Our Reference: SYD18/01119  
DP&E Ref: SSD 9452

**AUSTRALIAN MUSEUM – ALTERATIONS AND ADDITIONS (SSD 9452)**

Reference is made to the Department of Planning and Environment (DP&E) letter dated 22 October 2018, regarding the abovementioned application which was referred to Roads and Maritime Services (Roads and Maritime) for comment.

PUBLIC DOMAIN PLAN
AM ADDITIONS & ALTERATIONS

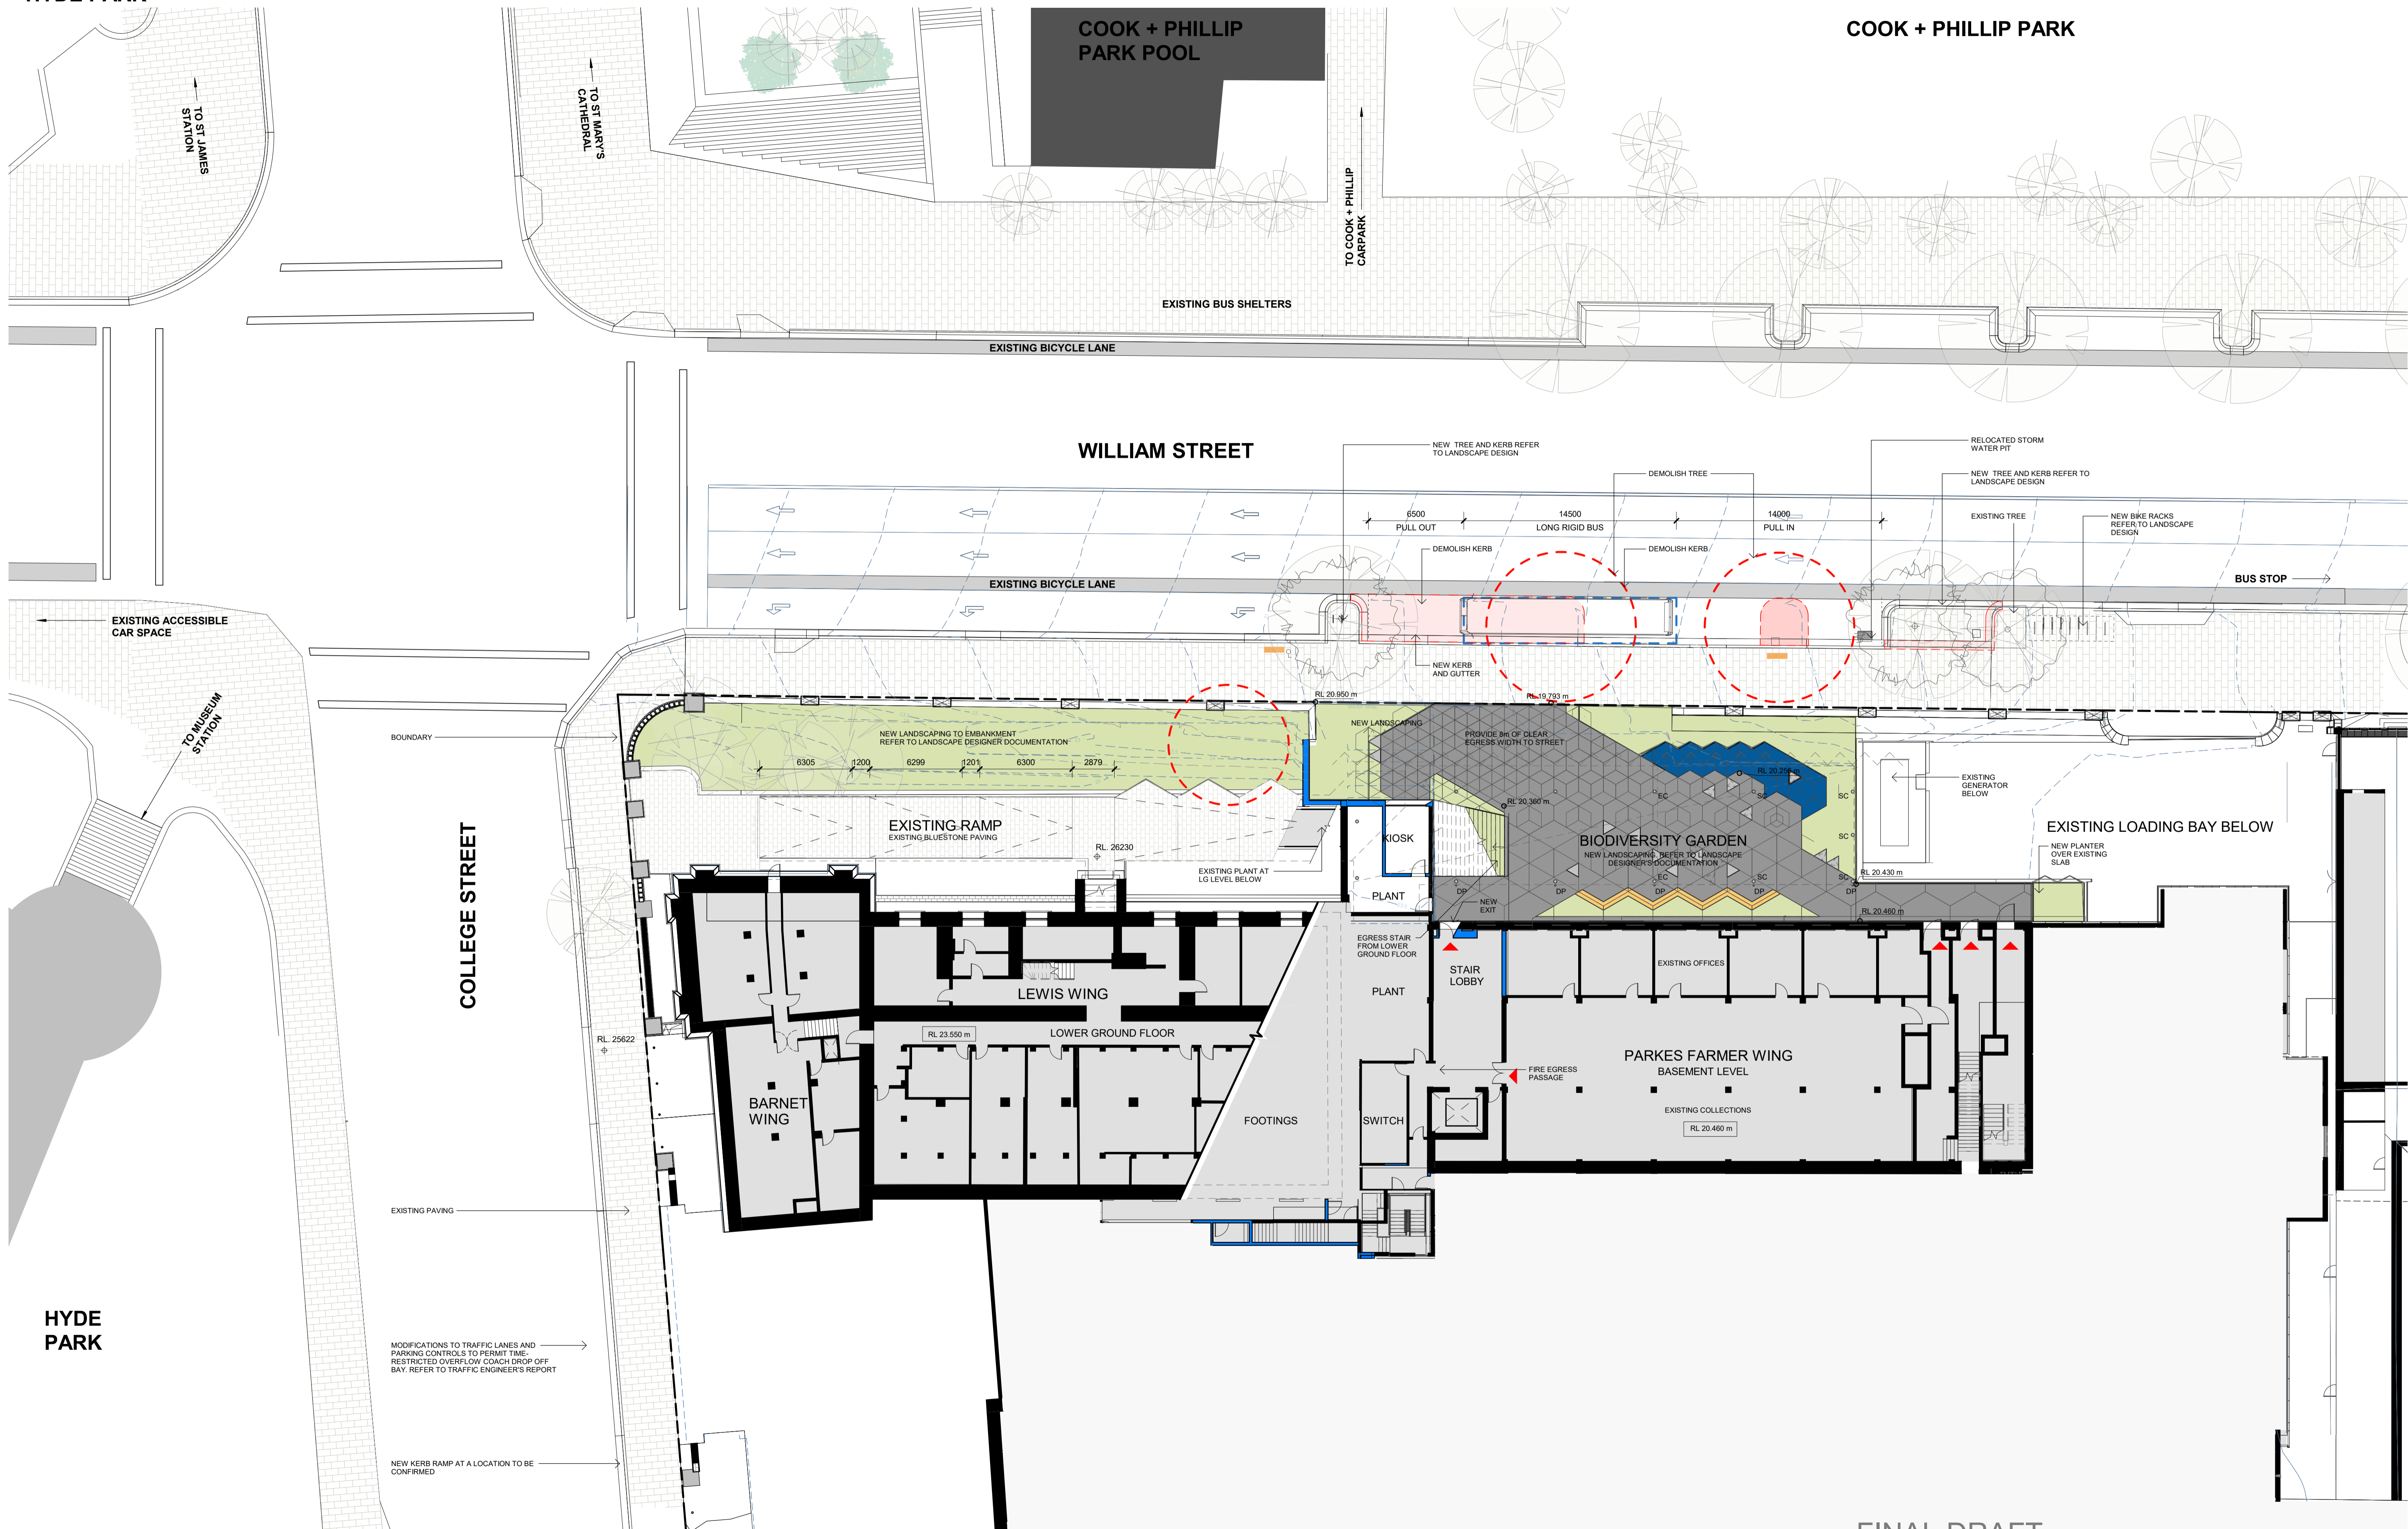
Roads and Maritime has reviewed the submitted application and notes that a new bus bay is proposed onto William Street. As such, concurrence in accordance with section 138 of the *Roads Act* 1993 would be required. Roads and Maritime provides concurrence under Section 138 of the *Roads Act* 1993 subject to the following conditions being included in any consent issued by DP&E:

Detailed design plans of the proposed bus bay kerb are to be submitted to Roads and Maritime for approval prior to the issue of a Construction Certificate and commencement of any road works.

4. Should the new bus bay involve the relocation of the existing bus stop on William Street, the former bus zone shall be designated a "No Stopping" area.
